**Objection to planning permission Ref. 3/2025/0845
Demolition of Offices and Replacement Office Building
The Village Hall, Franklin Hill, Brockhall Village, Old Langho**

[REDACTED] is instructed by [REDACTED] to object to planning application Ref. 3/2025/0845 by Prometheus Group Service Ltd. The application relates to the former village hall on Franklin Hill Brockhall Village and proposes:

"Demolition of the existing offices and construction of replacement office building".

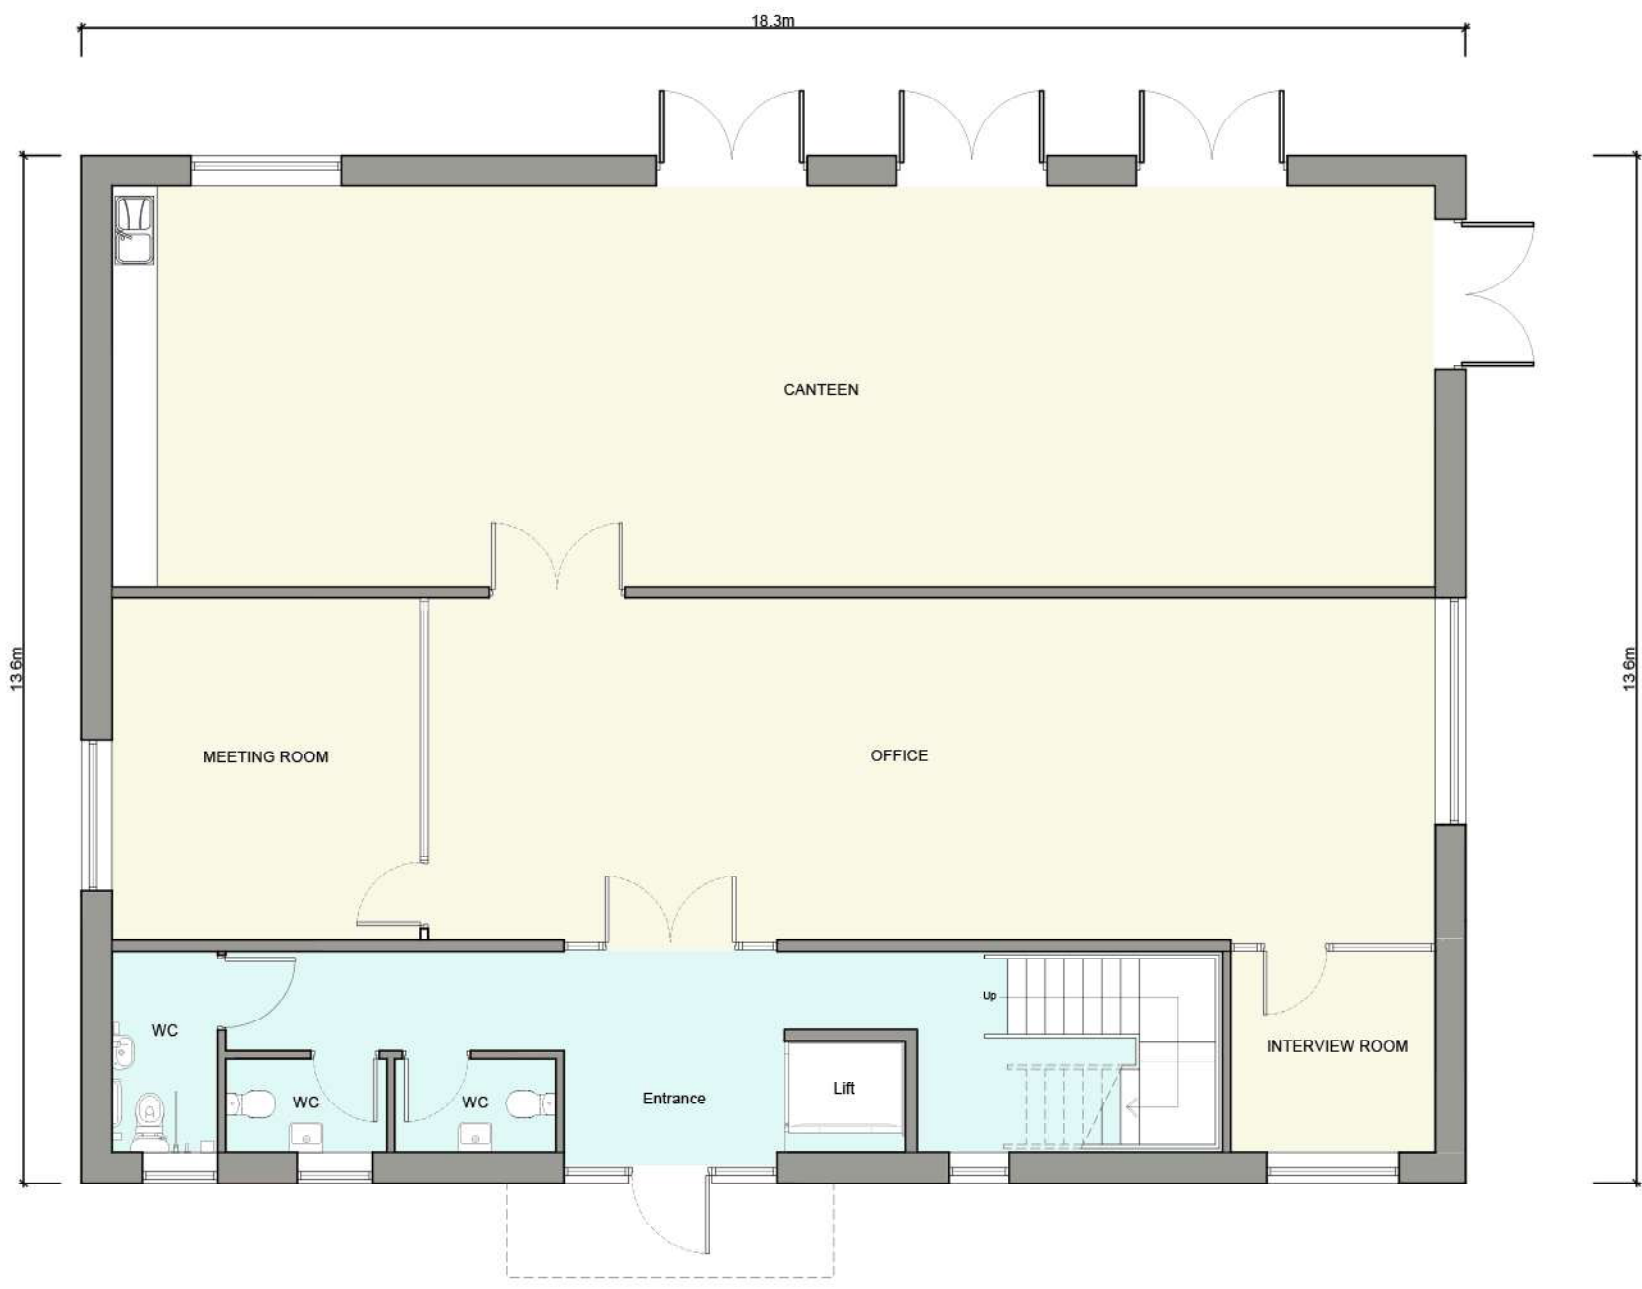
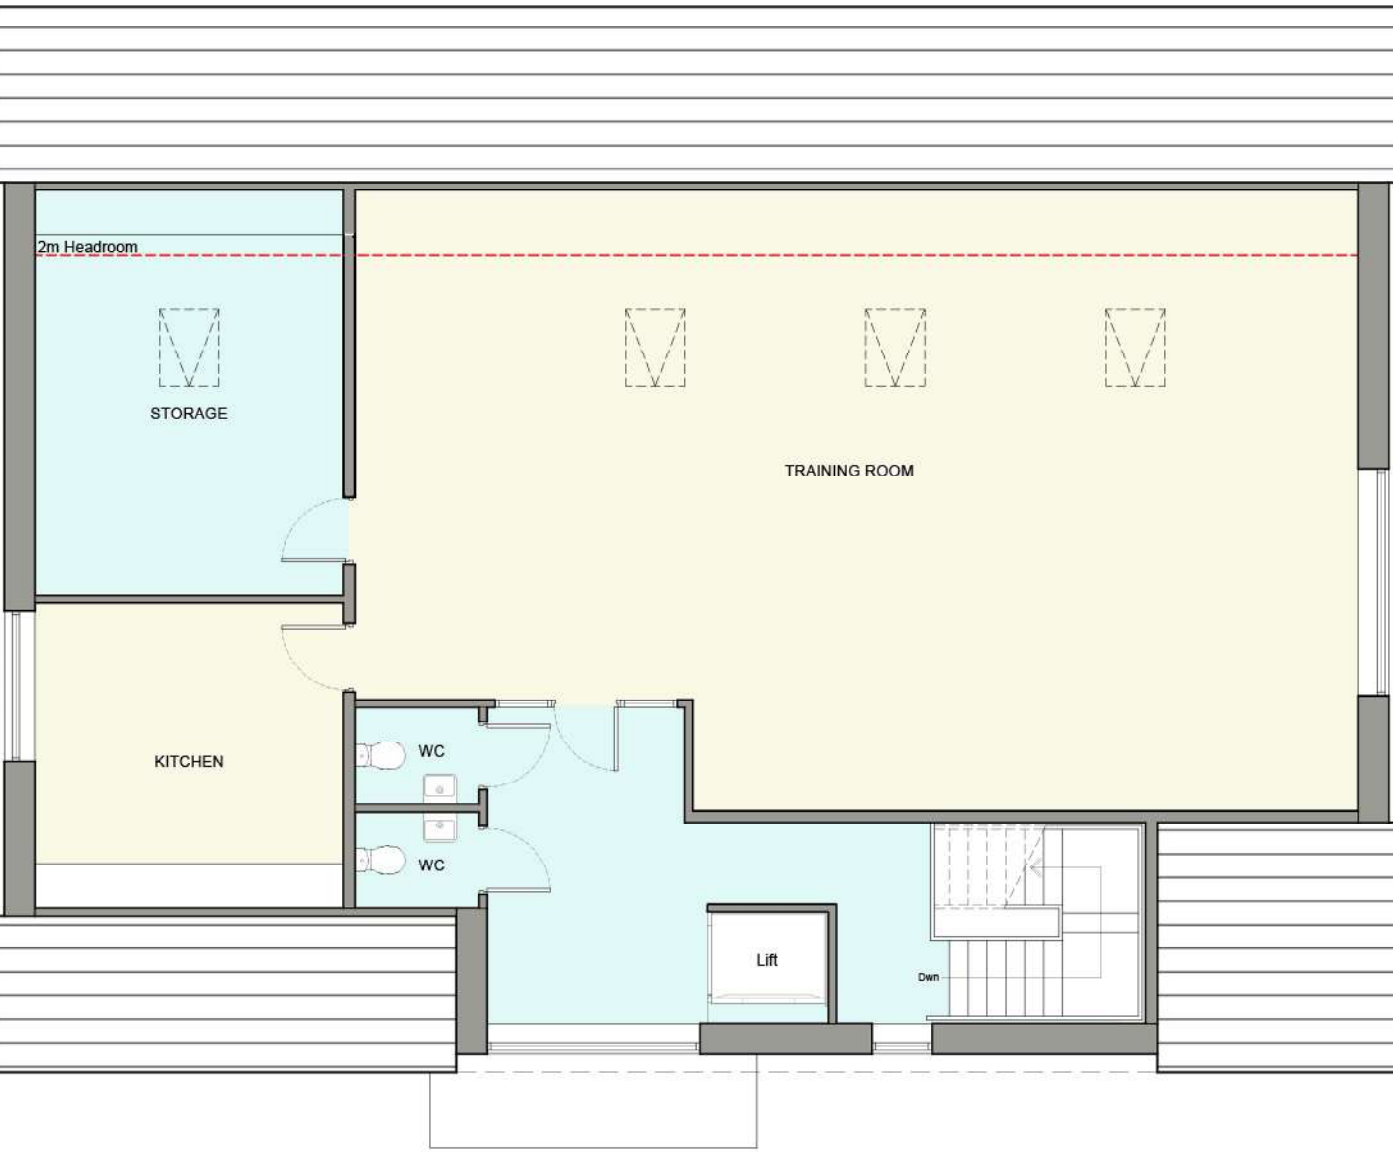
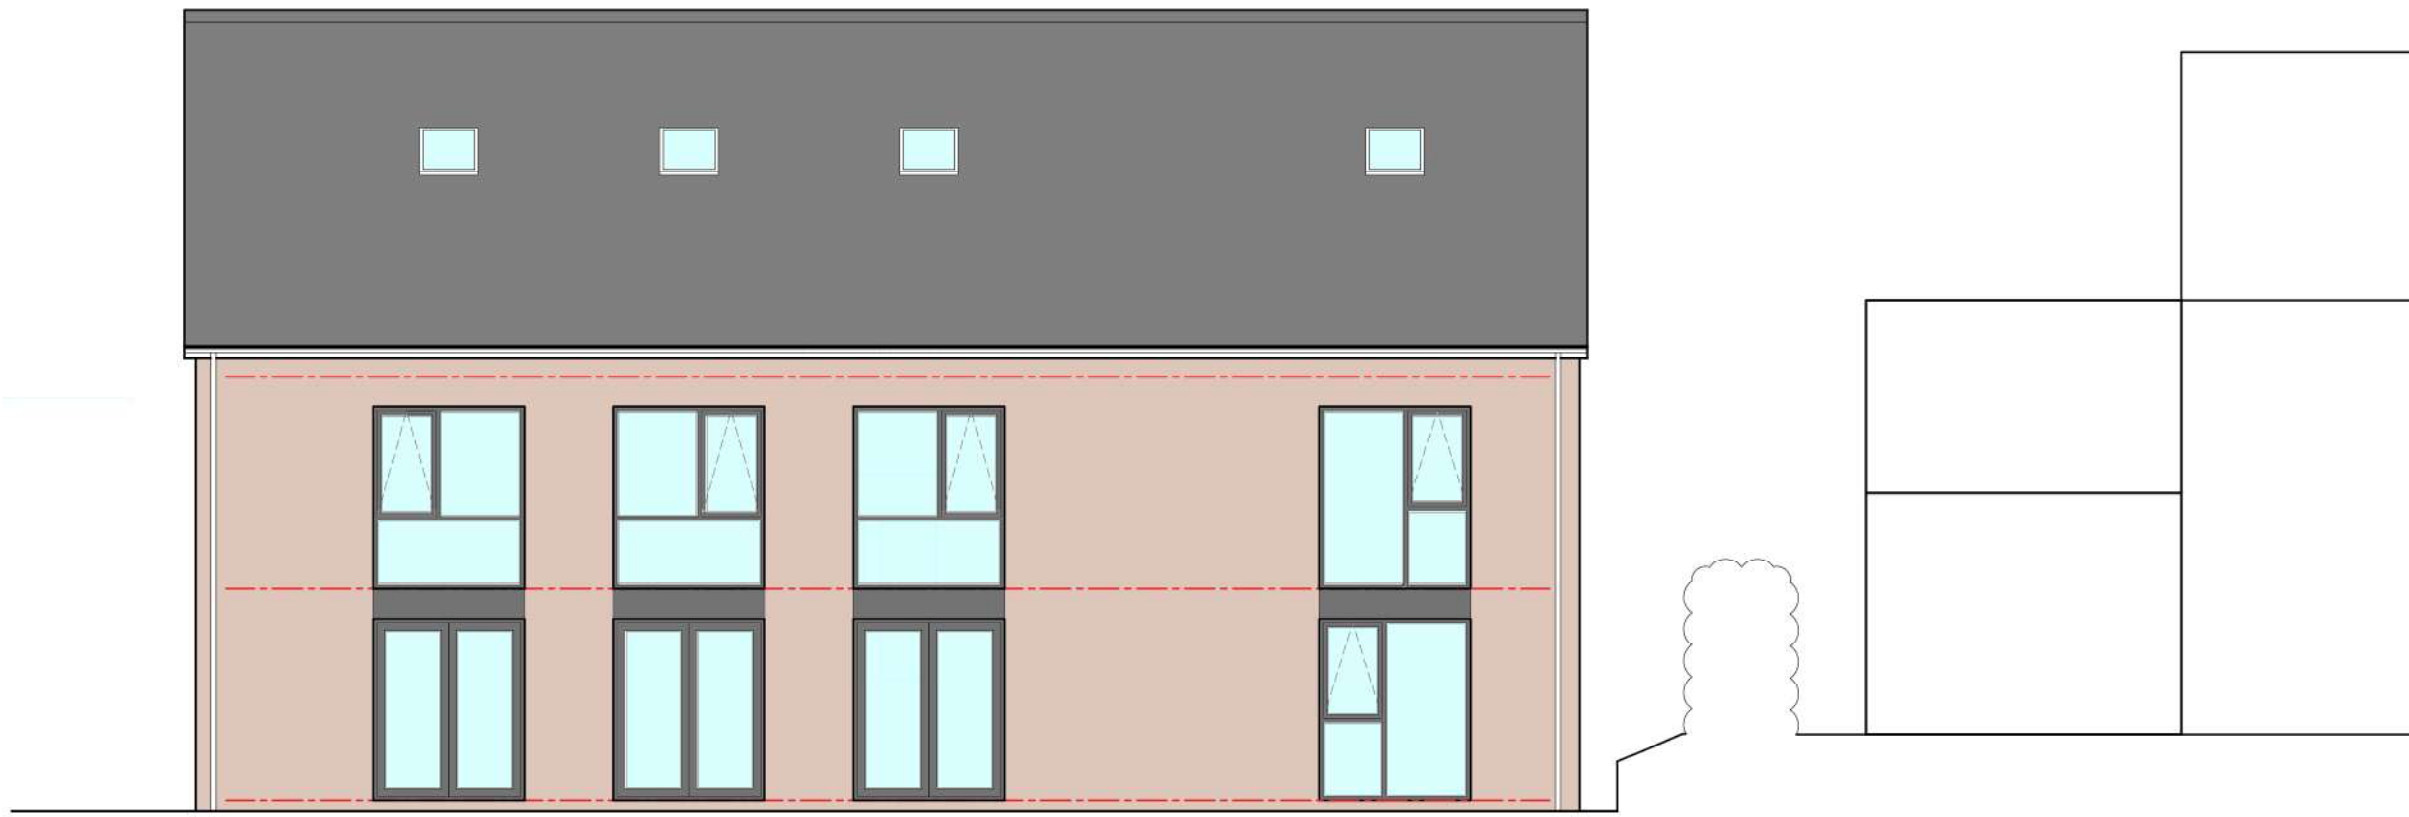
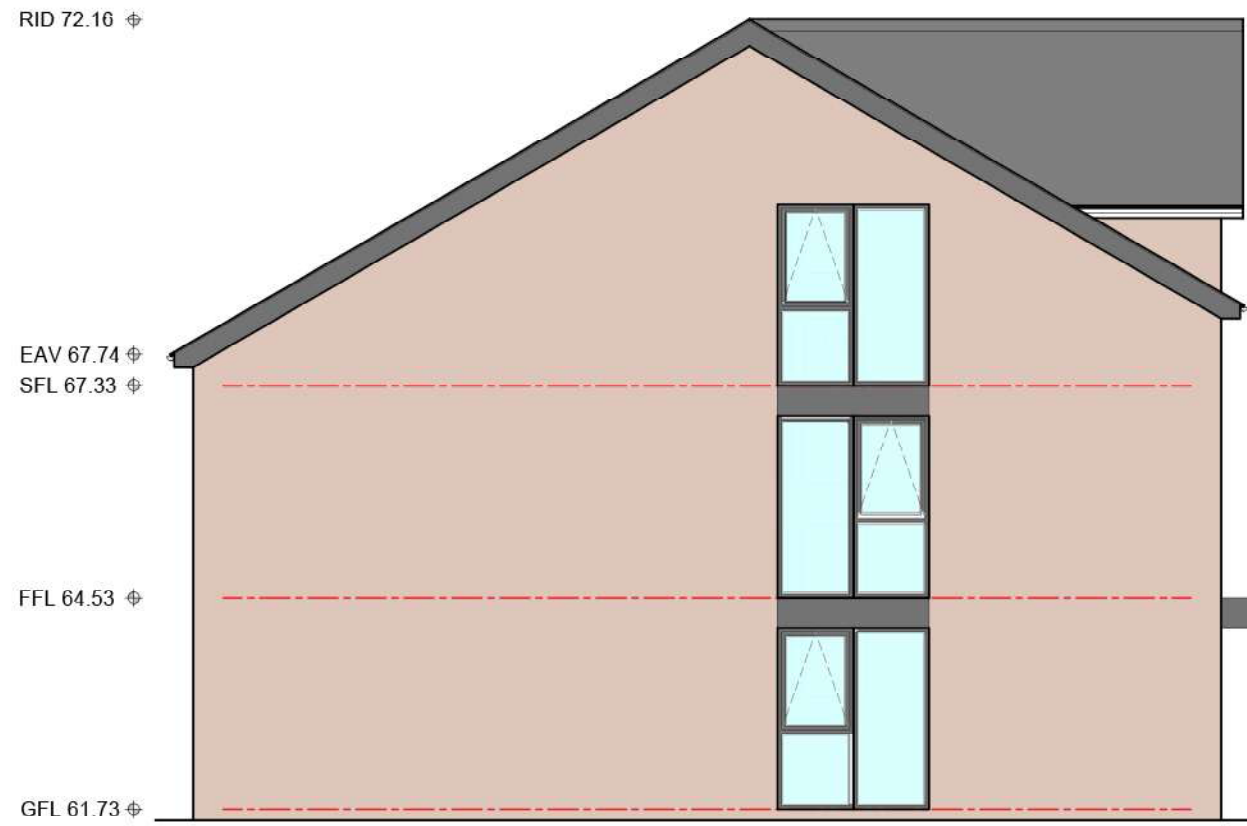
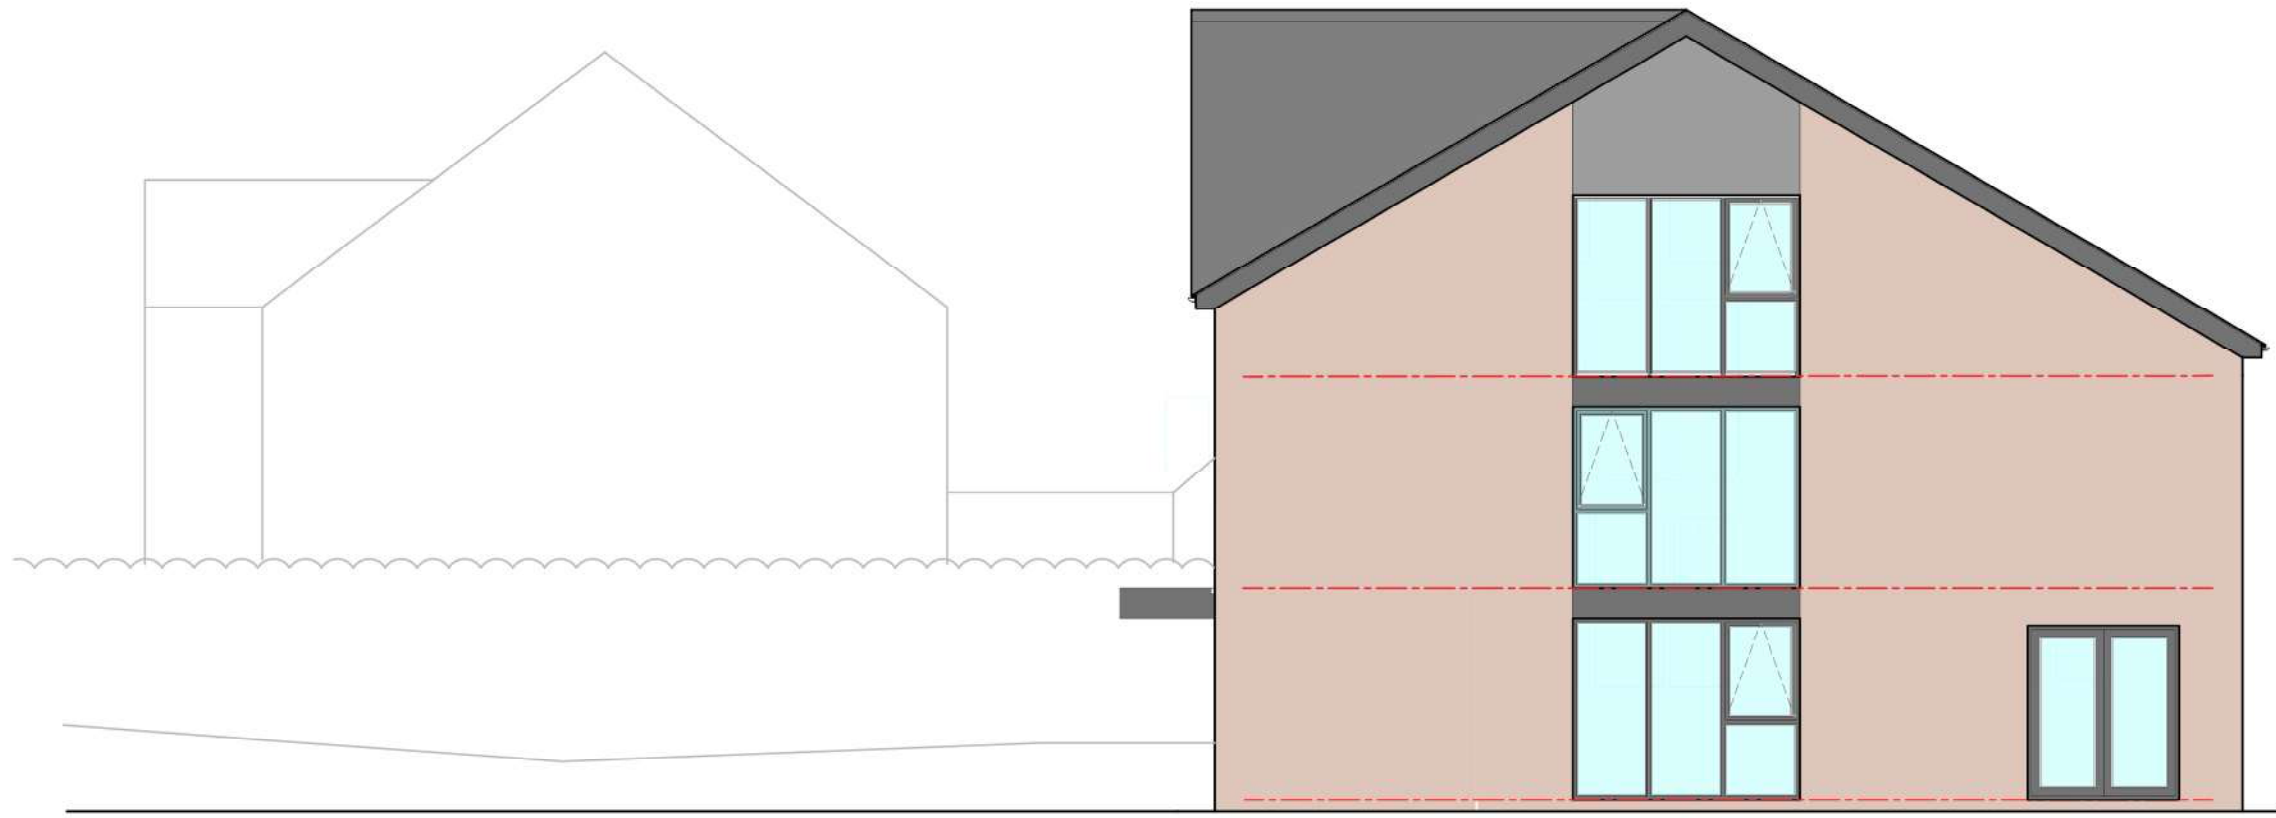
With regards the external appearance of the development, this does not have the appearance of an office building, but rather a residential dwelling / small apartment block. Modern office blocks are almost always designed with large areas of glazing and a regular window pattern to ensure maximum daylight. Indeed, the applicant has previously claimed that the existing building is entirely unsuitable for offices due to a lack of natural daylight. It thus appears very odd that they are now seeking planning permission for a new building with large open plan offices with limited windows and thus natural light.

The design and external appearance of the building is not considered typical of an office building. In fact, the building does not look like an office building at all. It also does not appear to address all the issues the applicant states are an issue with the current building i.e. limited light. The design and external appearance of the building is thus considered inappropriate as an office building.
